An
Bord
Pleanála

Inspector's Addendum Report ABP-303592-19

A 10 year permission for the construction of a windfarm comprising 24 x wind turbines, 1 x 110kV substation and all related works.

Derryadd Windfarm at Lanesborough, Co. Longford

Drawing No.: **10325-2006** Revision: **A**

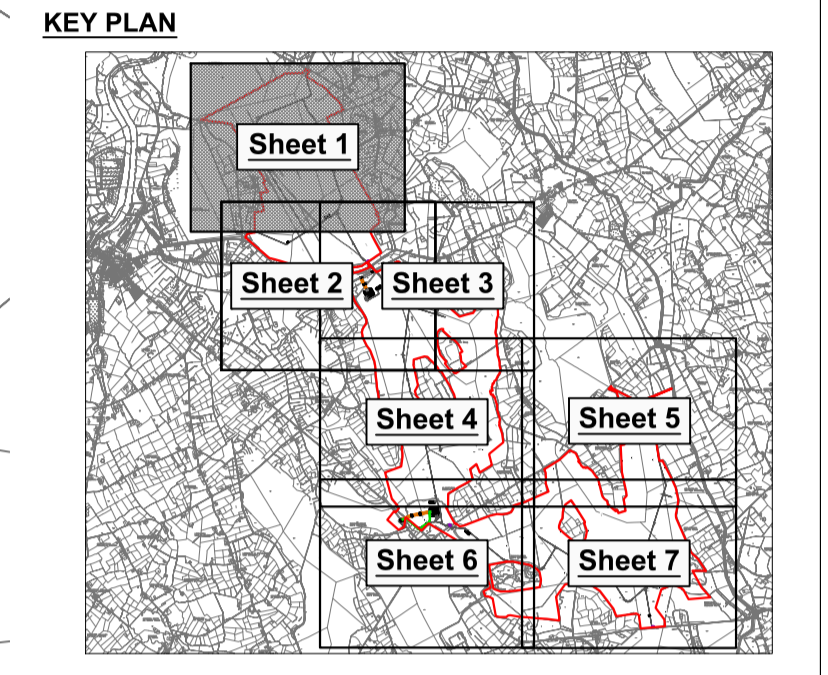
- Many drains will be blocked by the windfarm project and this combined with the peat berms (from construction) will assist in rewetting adjacent areas.

- This relationship is illustrated in Drg. Nos. 10325-2006 to 2012 & the windfarm design allows for the maintenance of the required key drainage infrastructure that facilitates the maintenance of the water level & site re-wetting.
